6 April 2021

SSD-8586218 - TEMPERATURE CONTROLLED WAREHOUSE FACILITY SECTION 4.55(1) MODIFICATION APPLICATION

The modification relates to correcting the stamped Site Plan approved as part of Mod 1 to SSD-8586218 for internal alterations including the installation of a cool room and freezer. This application identifies the consent and describes the error to be corrected. This application is accompanied by the Site Plan prepared by SBA Architects (**Attachment A**)

Figure 1: Site Plan

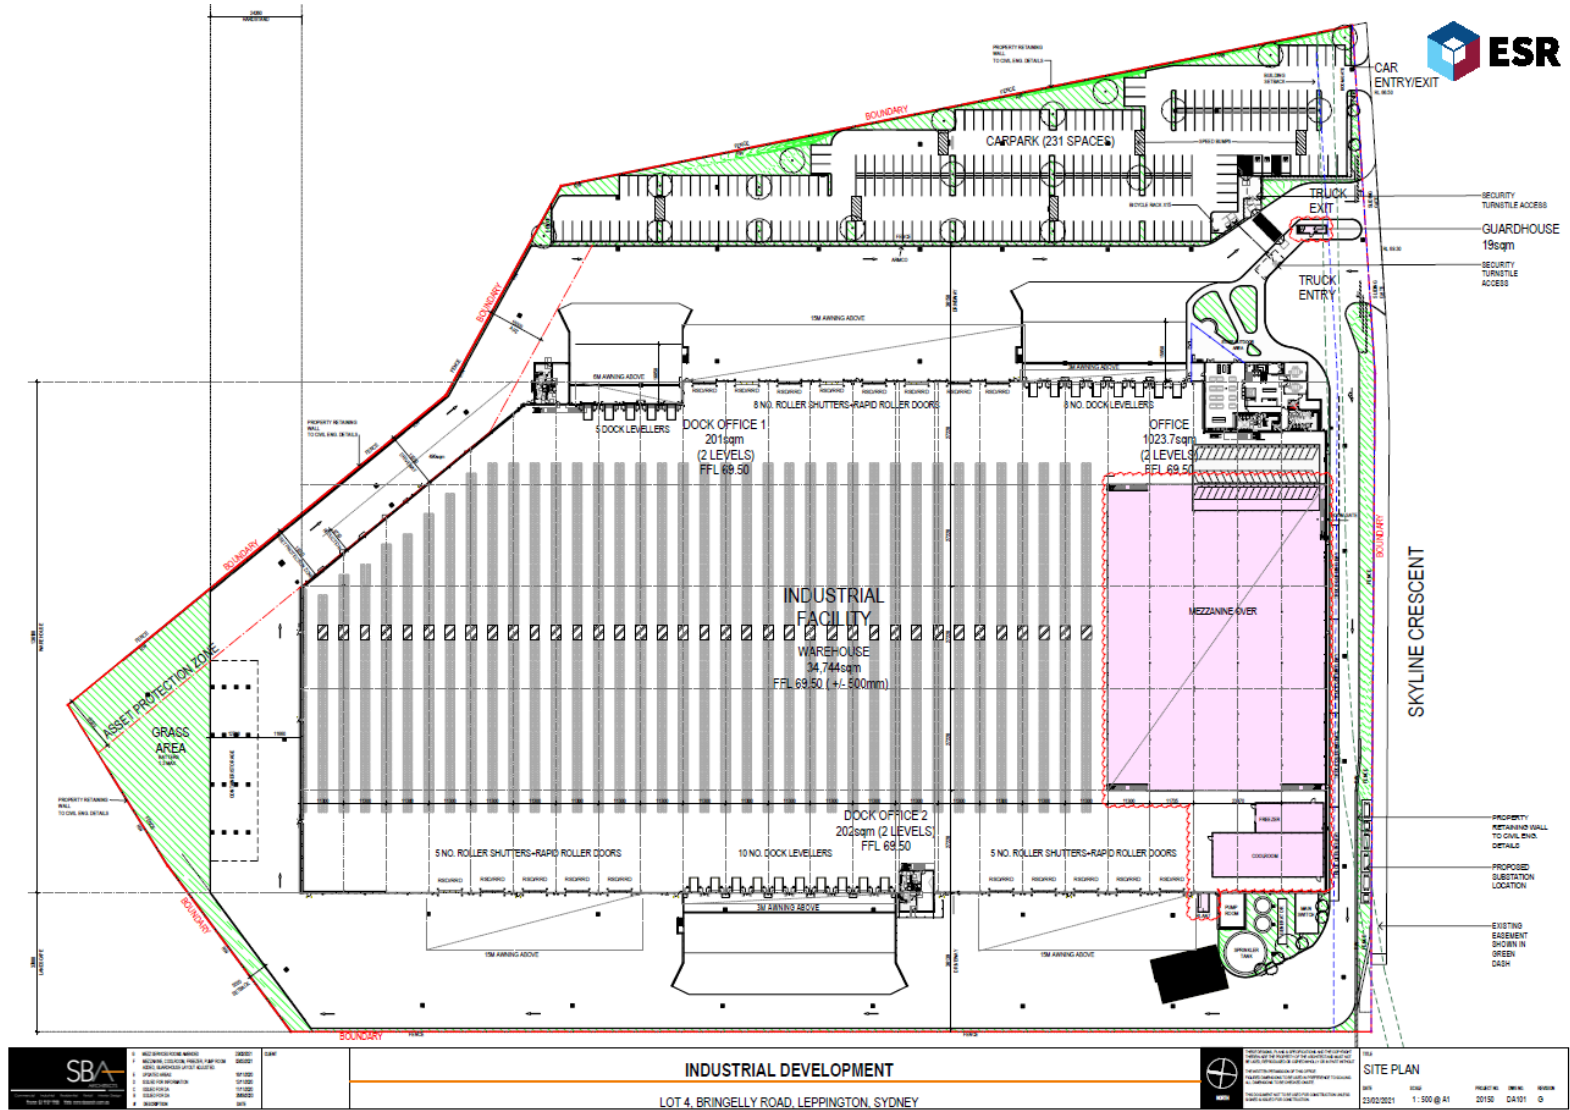
Modification 1 sought approval for the installation of an additional cool room and freezer located on the south eastern side of the warehouse (among other matters). Refer to **Figure 1** above for the location and size of the cool room and freezer as originally submitted with the Mod 1 application. The size of the cool room and freezer were unintentionally reduced on the Site Plan submitted in response to the DPIE's request for additional information. The incorrect Site Plan with the smaller cool room and freezer was subsequently approved and stamped by the DPIE. It is requested that this error is corrected by replacing the approved Site Plan with the Site Plan originally submitted with Mod 1.

The correct Site Plan has the same drawing reference as the incorrect Site Plan approved under Mod 1. Therefore, no modifications are proposed to the notice of determination. The only modification proposed is that the stamped Site Plan is replaced with the Site Plan originally submitted with Mod 1 and provided again as **Attachment 1**.
